The Sizewell C Project

5.6 Sizewell Link Road Flood Risk Assessment Addendum Appendices

APPENDIX B: Collated comments from the Environment Agency received on 5th February 2020, 4th August 2020, 14th September 2020 and 30th April 2021

APPENDIX B: COLLATED COMMENTS FROM THE
ENVIRONMENT AGENCY RECEIVED ON 5TH FEBRUARY
2020, 4TH AUGUST 2020, 14TH SEPTEMBER 2020 AND 30TH
APRIL 2021

Plate 2.5. Proposed cross-section of the diverted channel at crossing SW1.

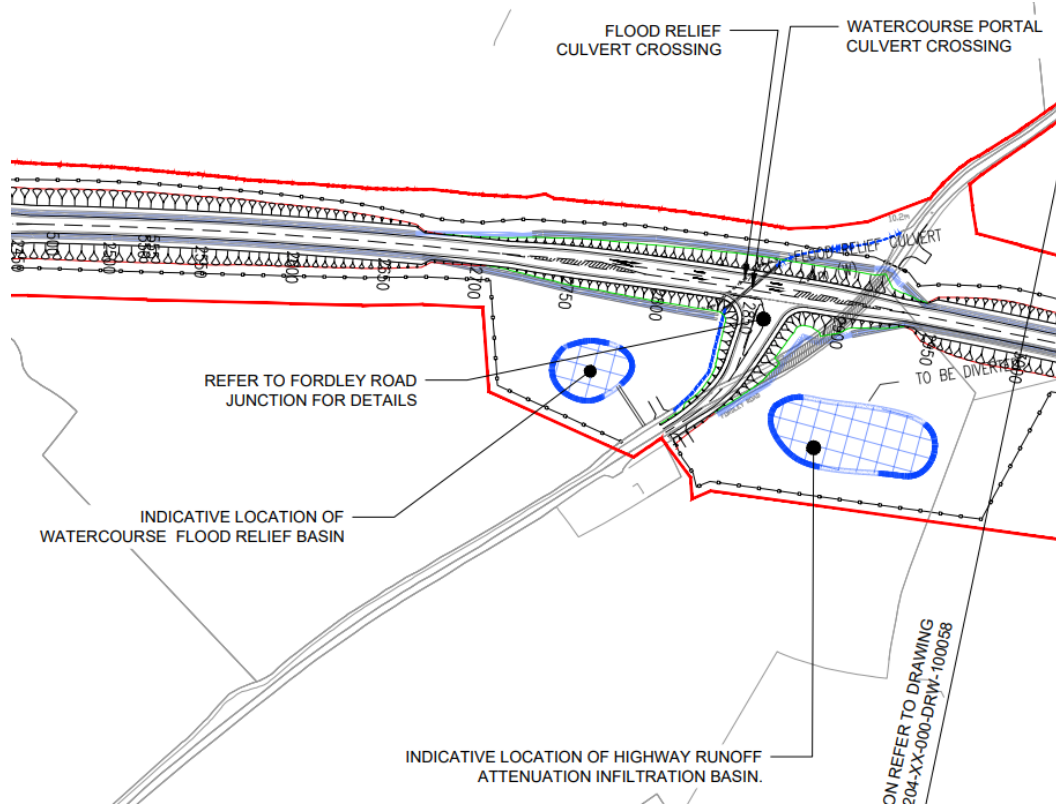
6.1	Sizewell Link Road Fluvial Modelling Report	Plate 2.5	The proposed cross section of the new diversion channel at SW1 is substantially larger than the current watercourse.	The cross section of the existing watercourse is understood to be approximately 1.5m² this drawing shows the top of the channel to be 9.4m wide which is much larger. The FRA also does not explain how the channel will be constructed. The new channel should be as natural as possible.	Please explain why the cross section shown has been chosen and why it does not replicate the existing channel. Provide cross sectional survey obtained to show existing channel dimensions to provide a comparison to the proposed design.	1	05/02/2020	Further details of the design of the re-aligned channel have been provided in the Modelling Report Addendum and the FRA Addendum.	The modelling cross sections show that the existing channel has dimensions of 5.5m top width and 1.5m deep, with very narrow bed, and an approximate cross-sectional area of 4m². The proposed channel has a bed width of 1m, top width of 10m, height of 1.5m and cross-sectional area of approximately 10m², so more than double the existing channel area. It appears that the proposed channel is trapezoidal. From a biodiversity perspective we would rather see a stepped marginal plant ledge on at least one side of the watercourse, on the lengths of watercourse either side of the crossing, in order to ensure that there is a vegetated area in the watercourse. The proposed mammal ledge must be raised above the 1% flood level, but it is not clear whether this is the case, so this should be clarified by showing the flood extents on the portal culvert cross section.	Not yet. Realigned channel should be designed with a marginal stepped ledge, and cross sections of portal culvert should be provided.	The design has considered current guidance on the required width of the watercourse and the mammal ledge, i.e. 1 in 3. A channel incorporating a stepped ledge can be considered at the detailed design stage, however it would be designed such that it would maintain conveyance capacity of the channel and therefore it would not have an impact on the existing conclusions set out within FRA Addendum or the accompanying Modelling Report Addendum.

Plate 2.11. Proposed layout at crossing SW5.

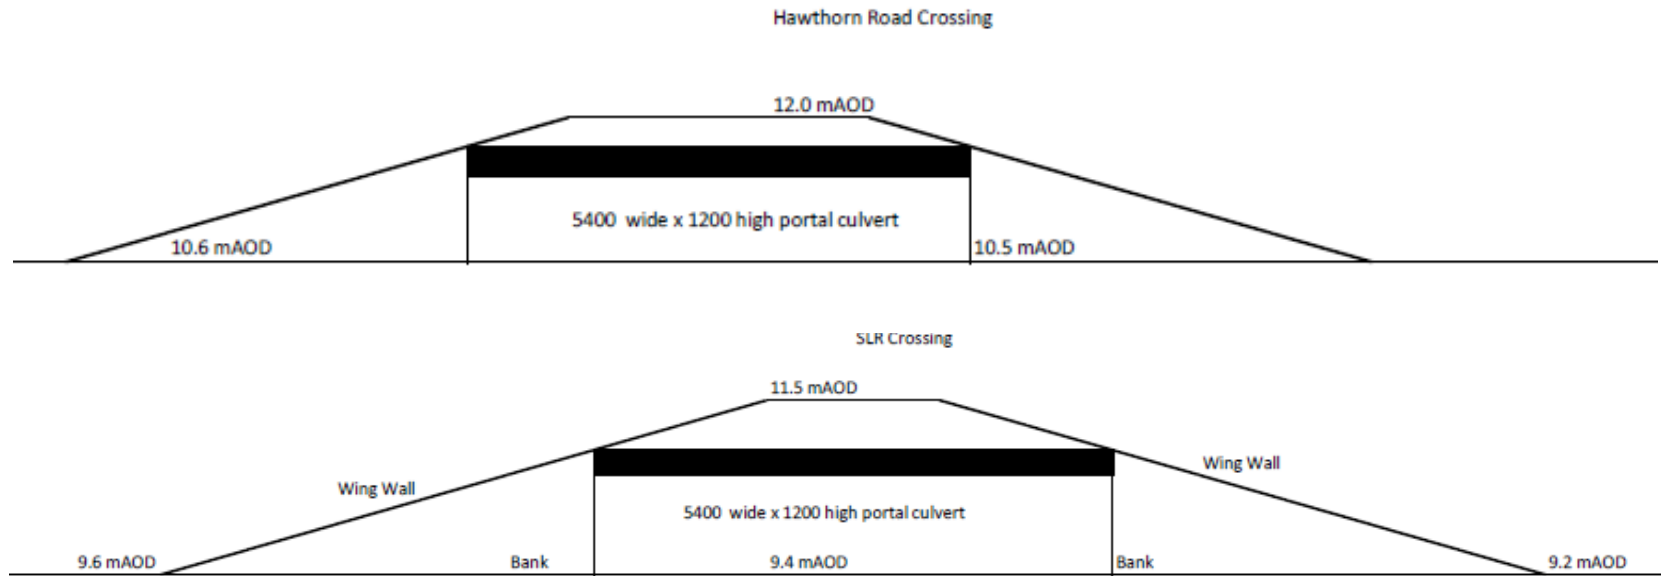
1.4	SZC Bk5 5.6, AppxA, Size well Link Road Modelling Report.pdf	Plate 2.11/Hydraulic model	Discordance between what is shown in Plate 2.11 and what is represented in the hydraulic model at crossing SW5	The proposed layout for SW5 is at odds with what is represented in the model. Plate 2.11 shows a 5400mm wide 1200 high culvert yet cross section SW005B shows a width of 6.4 metres. In addition the bank heights do not align. Plate 2.11 shows 12.2mAOD but the model suggests bank levels are lower than that	Correct the model or plate in the report depending on which is incorrect	1	14/09/2020	The model has been revised with additional survey data and the latest / improved (where required) design information. Updated results and further details on the modelling are provided in the Modelling Report Addendum.	N/A	N/A	This comment was not included within the review comments received from the Environment Agency dated 30th April 2021. It is considered that, as the assessment has progressed, this comment is no longer of relevance and has been superseded by the updated comments received in April 2021.
